Re: Mark Armijo Academy
Neighborhood Impact Assessment (L10D007)
DRAFT Report October 2024
Via email jkruse@lee-eng.com

The subject Traffic Impact Study (Study) draft received on October 2nd, 2024 , has been reviewed by the City of Albuquerque Planning Development Transportation Section. The City has the following comments and questions to be addressed.

TRAFFIC CIRCULATION LAYOUT

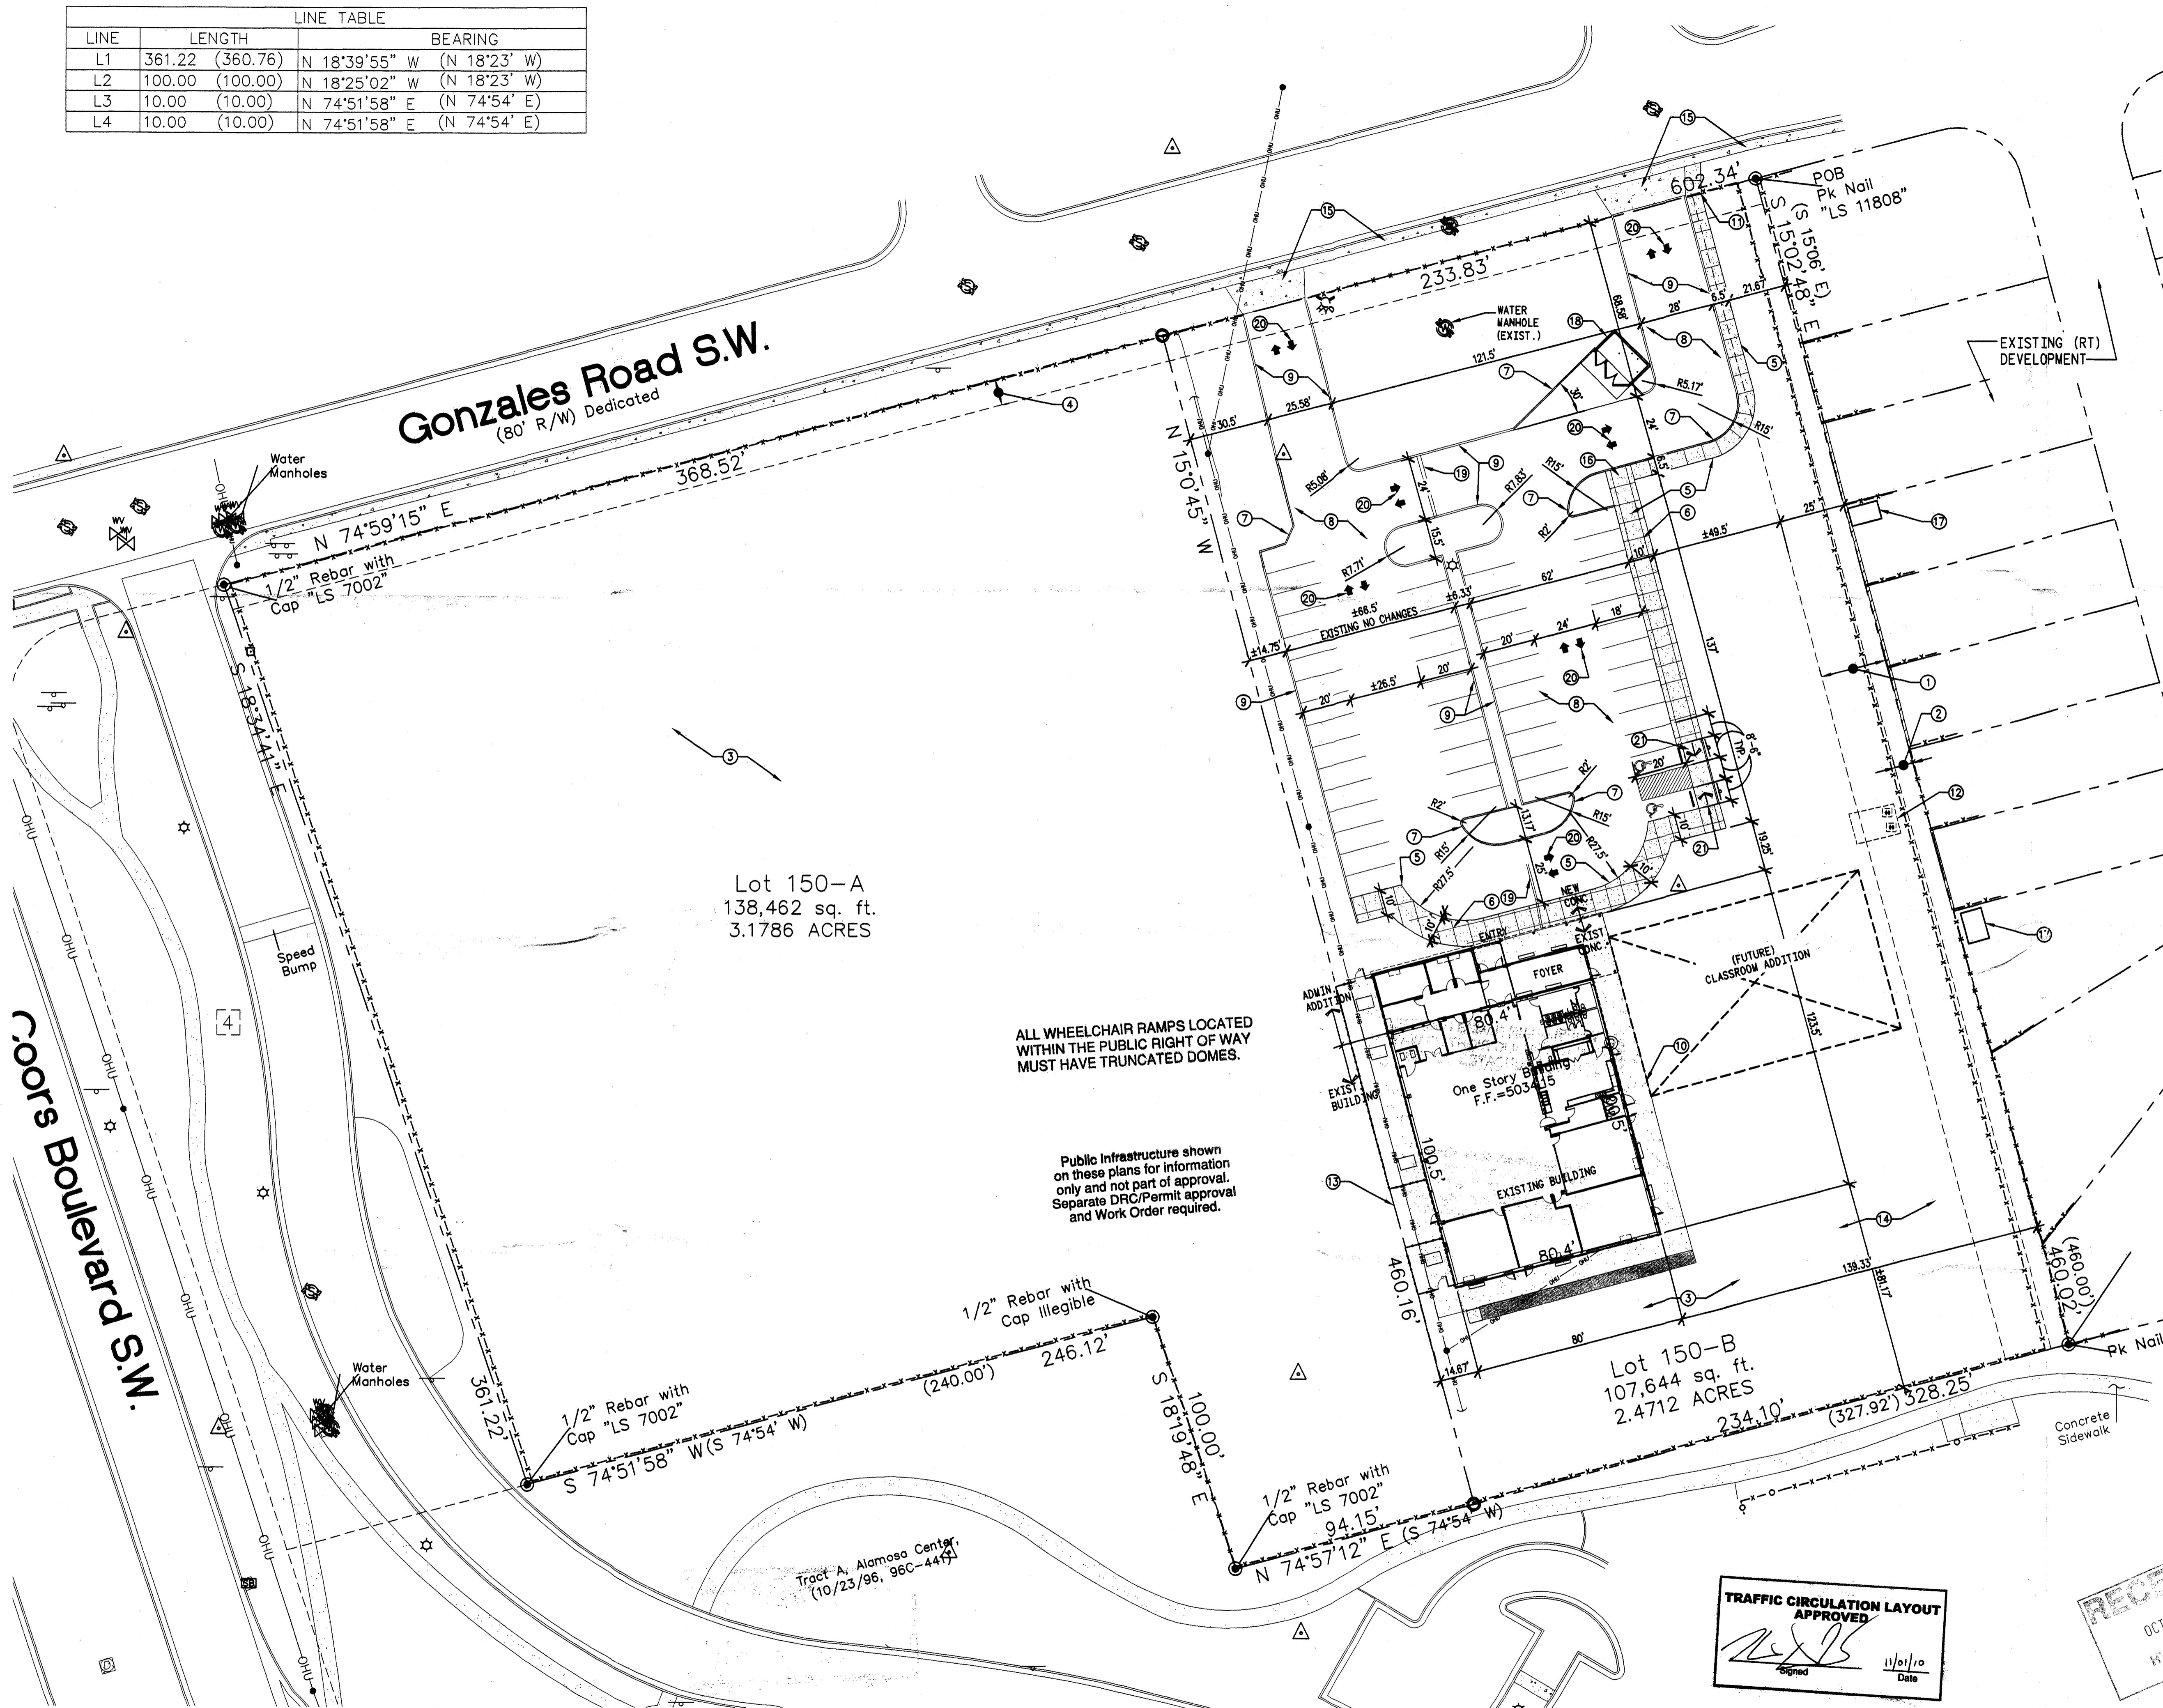
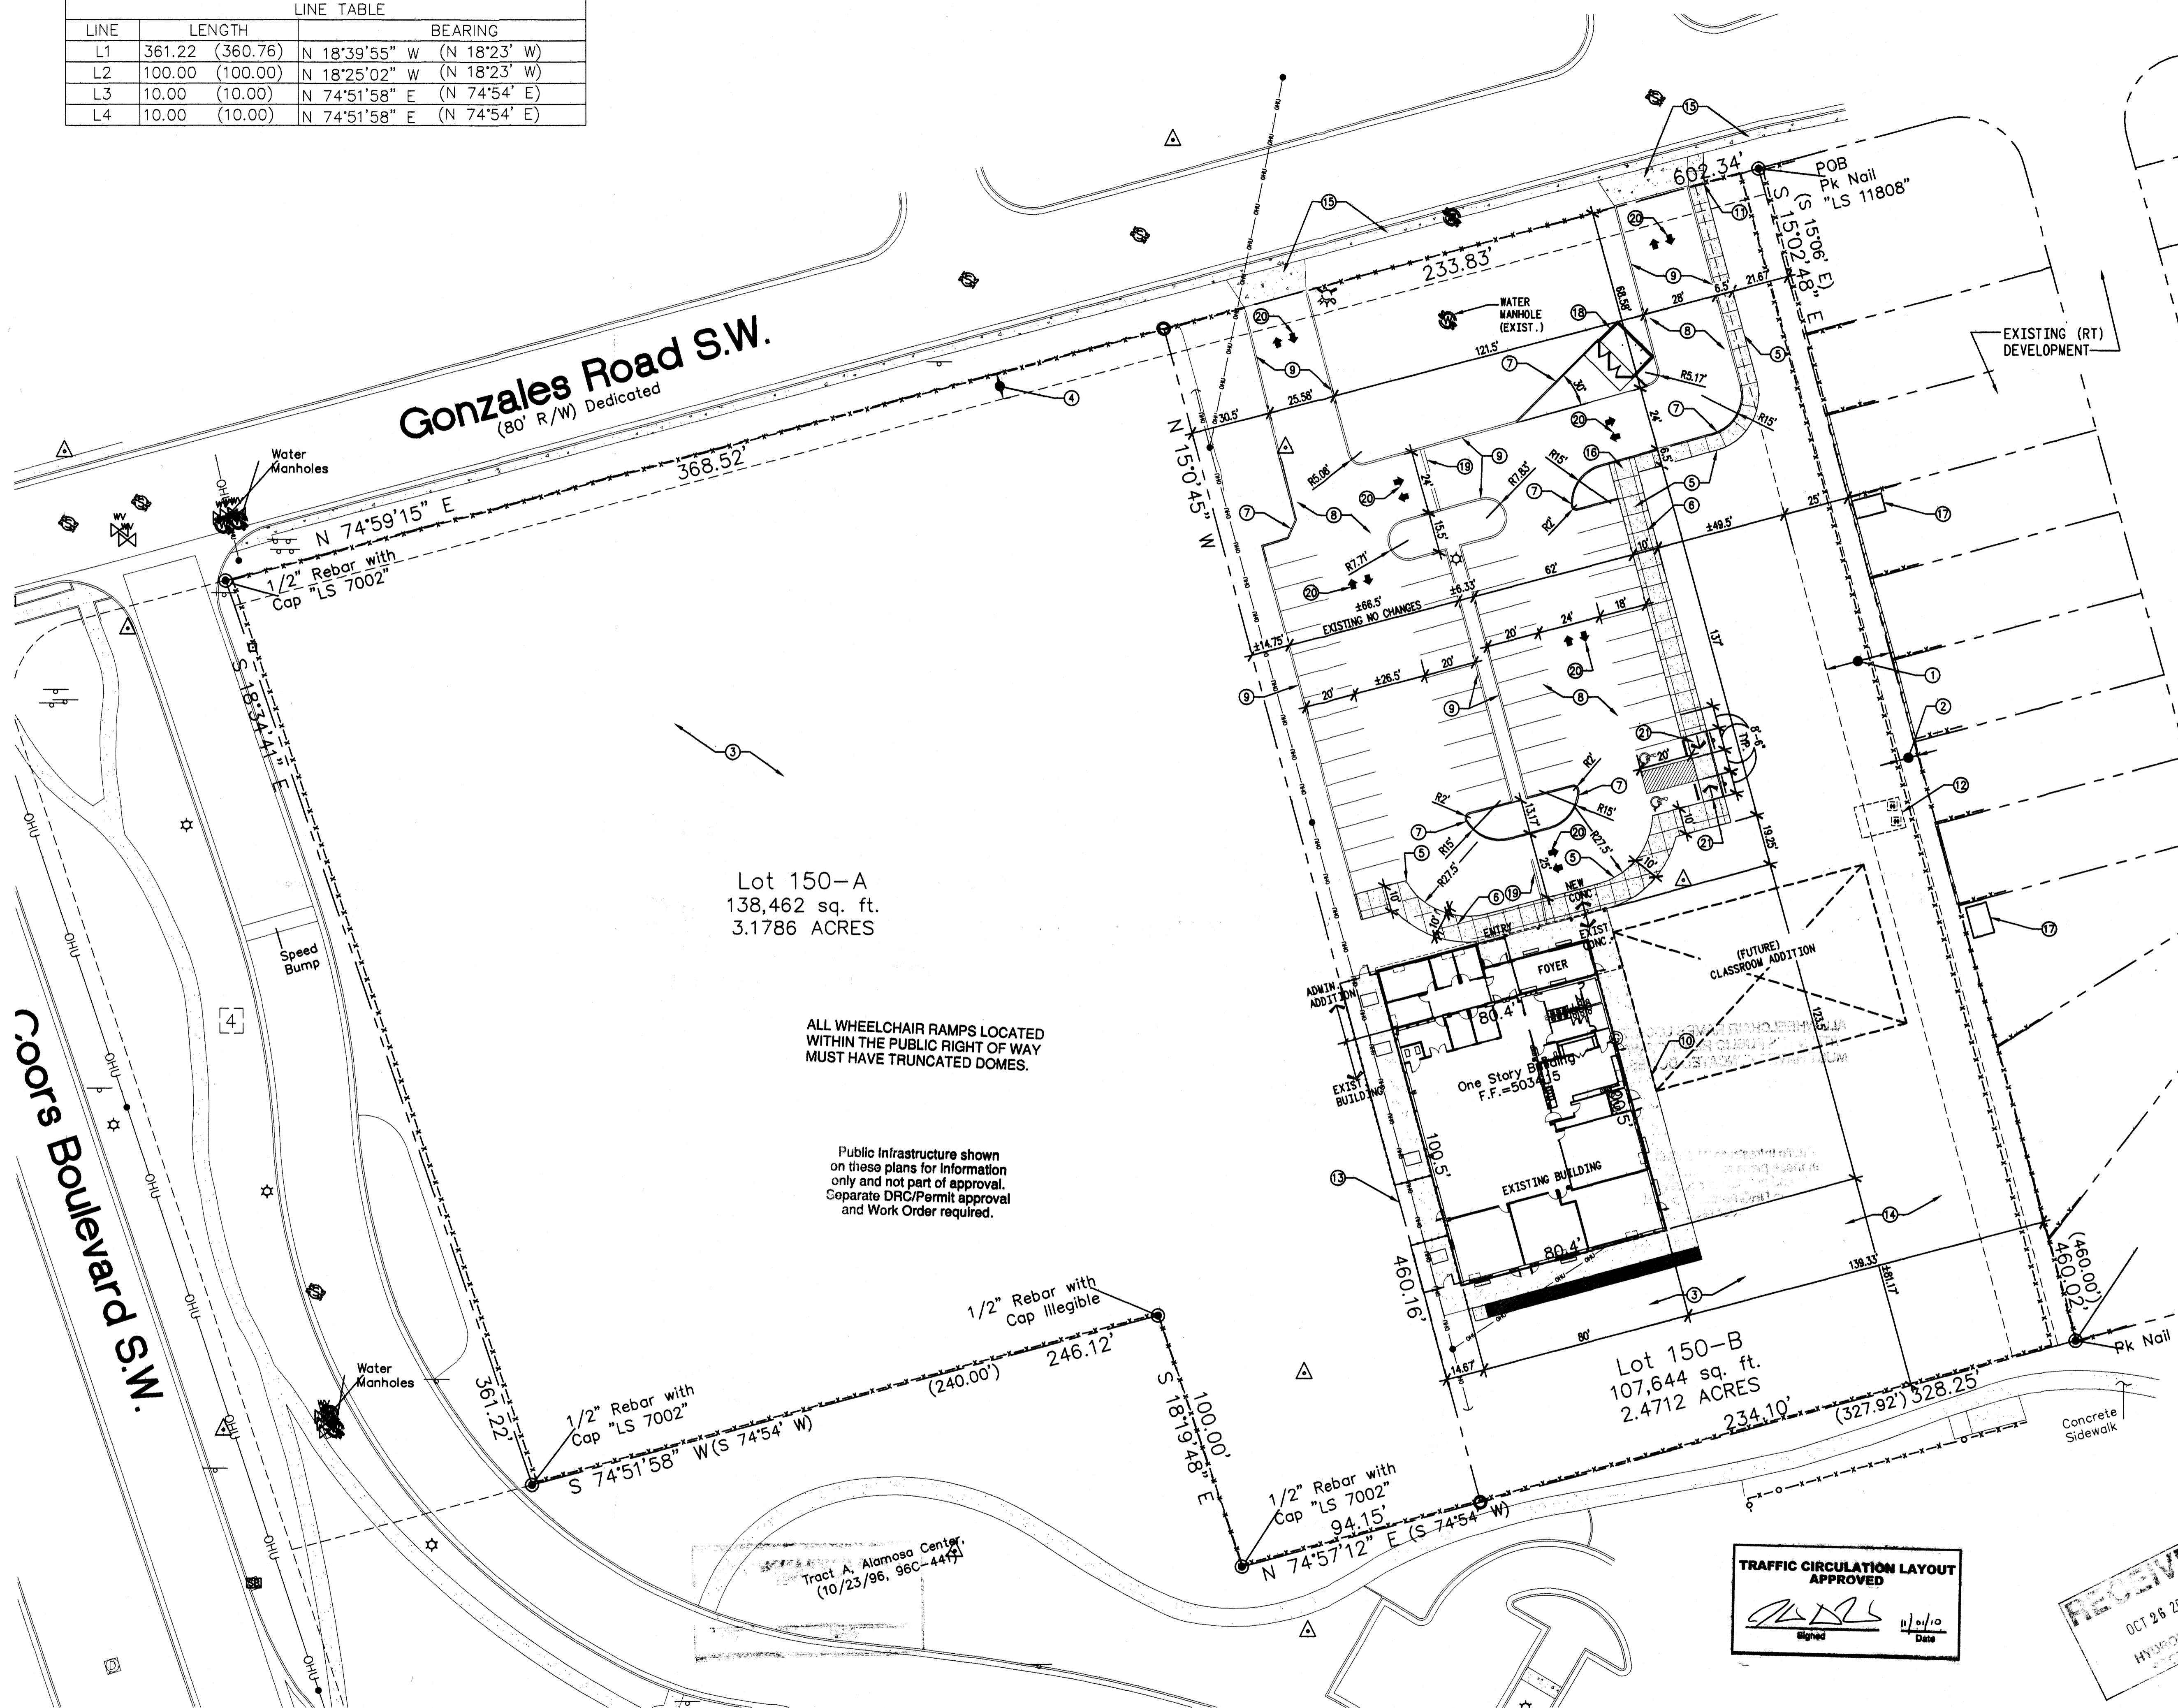
3. For the Site recommendation for right-in operations lane delineators or similar will be needed. Show a proposed method for the right-in operations on the Site Plan. It should not interfere with the left-out for southbound 69th St.

6. Provide a clear Site Plan that is a minimum of 11x17 inches. Site Plan to include transportation related features and dimensions rather than a grading and drainage plan as was provided with this submittal.

7. Provide dimensions from the centerline of the proposed driveway to the: centerline of 69th St on the opposite side of Gonzales Rd and to the driveway to the community center.

8. Queueing onto Gonzales Rd should be prevented. Demonstrate the available vehicle queue length for the drop-off/pick-up lane on the Site Plan.
9. A site visit revealed there is a 3-1/2" to 5" drop off at the back edge of sidewalk along the School's frontage on Gonzales Rd from the existing west driveway to the western property line. This is to be mitigated as it is a fall hazard.
